From: Natalie McKellar [REDACTED]
Sent: 08 December 2017 15:54
To: Anita Gardner
Cc: Kerry Simmons [REDACTED]
Subject: Kite Surf Cafe @ Littlehampton. LU/30/17/PL
Importance: High

From: Jim Henn [REDACTED]
Sent: Thursday, December 07, 2017 5:54 PM
To: 'Rudi Tyrrell' [REDACTED] <'rudi.design.co@gmail.com' <[REDACTED]>>
Cc: Phil Graham [REDACTED]; Sarah Radley [REDACTED]
Subject: Preliminary revisions for Kite Surf Cafe @ Littlehampton. LU/30/17/PL

PLANNING ISSUE DRAWING
REV B: Access lifting platform and window added, balustrade materials altered, 07-12-2017
REV A: Floor levels AOD added 06-11-2017

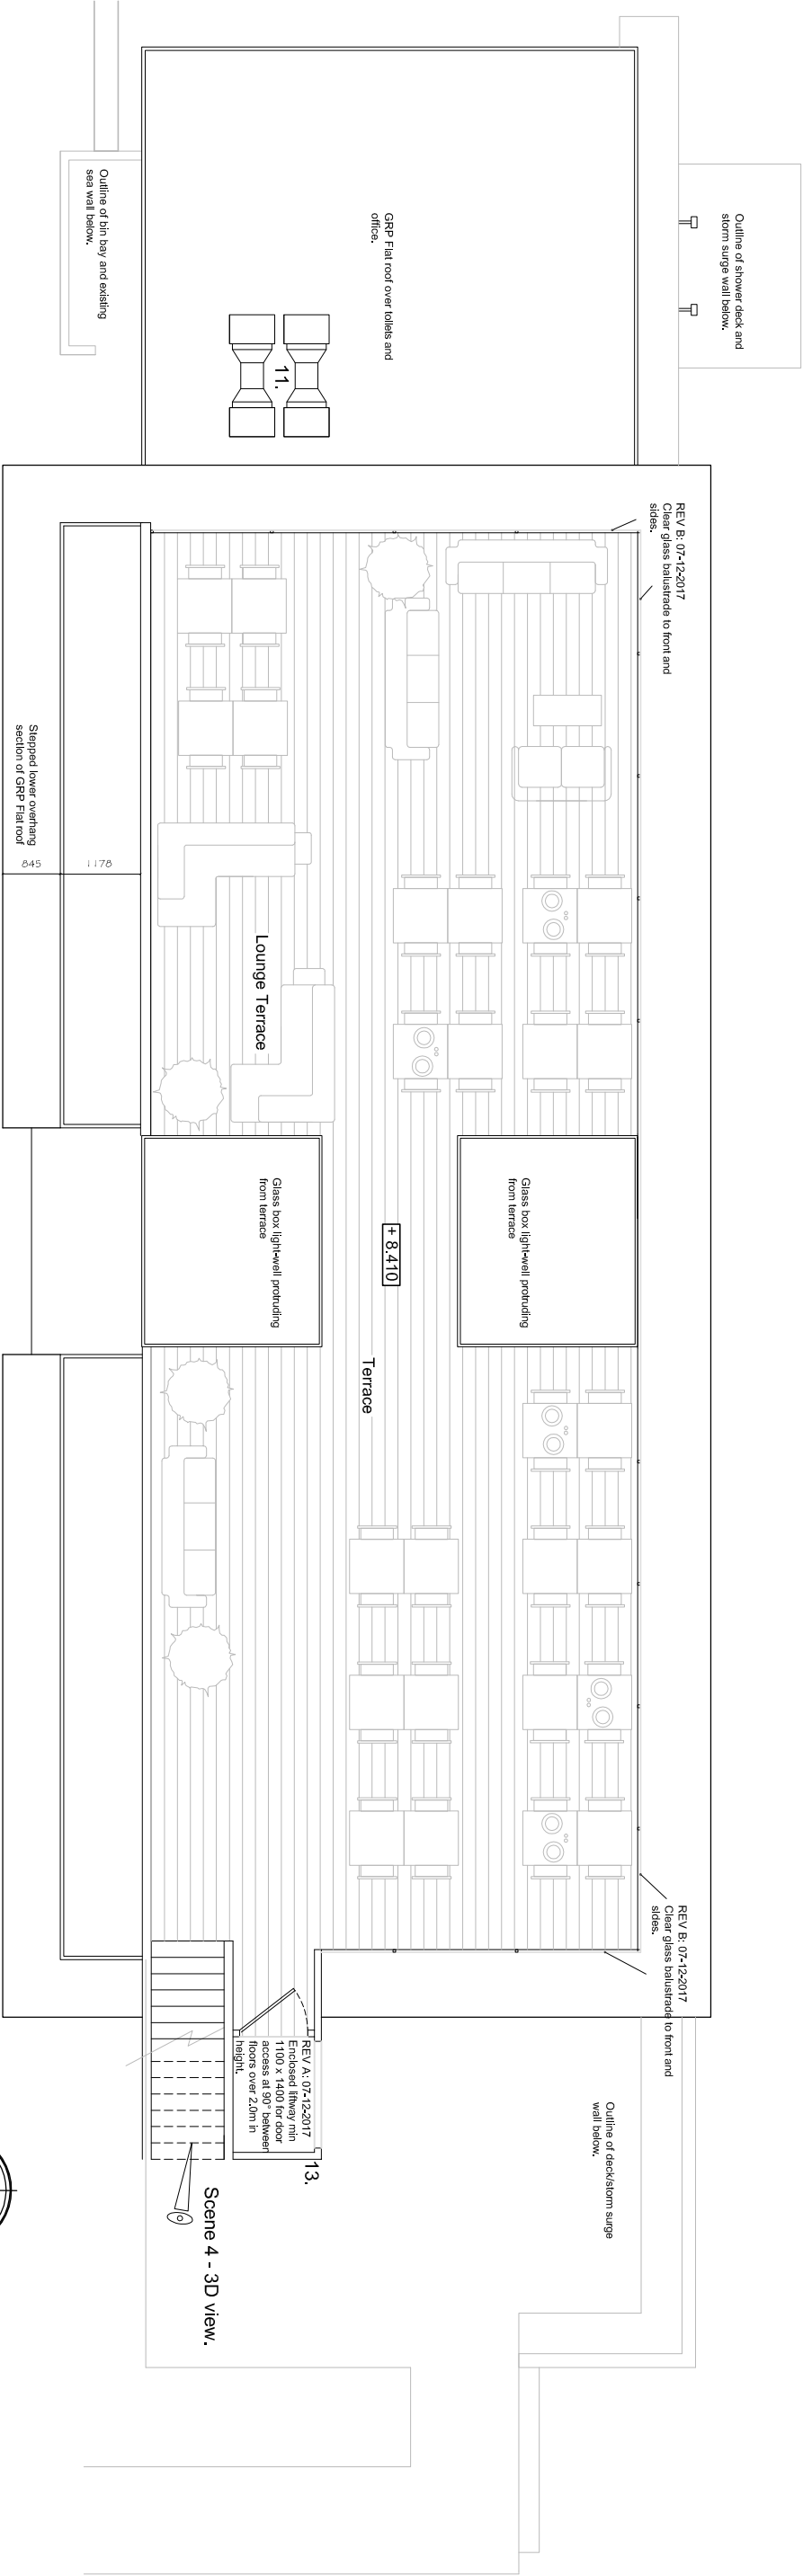
- The lifting platform is enclosed on the sides as it has a rise of greater than 2m
- It is sized correctly for a platform with doors at 90 degrees to each other and for a wheelchair user and their companion. (clauses 3.43 in ADM and 8.5.3.2 in BS8300)
- The door width will meet the minimum 900mm requirement in the clauses above in Part M and BS8300
- The use of the lift is to provide access to an open roof terrace, if the user is unable to use the stairs.

In this circumstance as the only access to the open roof level terrace for able bodied people is via an external staircase, the principle of a lifting platform rather than a passenger lift is reasonable.

Please note that when the building regulations application is made more detailed information will be needed including where the machinery is located, how the lift is called, how the doors are opened, visual contrast etc.

Further to your previous email regarding the above application going before the Development Control Committee on 13th December I attach amended plans showing the lifting platform added to the proposals in order to allow wheelchair access to the first floor roof terrace. These have been discussed with Arun's Building Control department and have come about in order to satisfy Part M requirements.
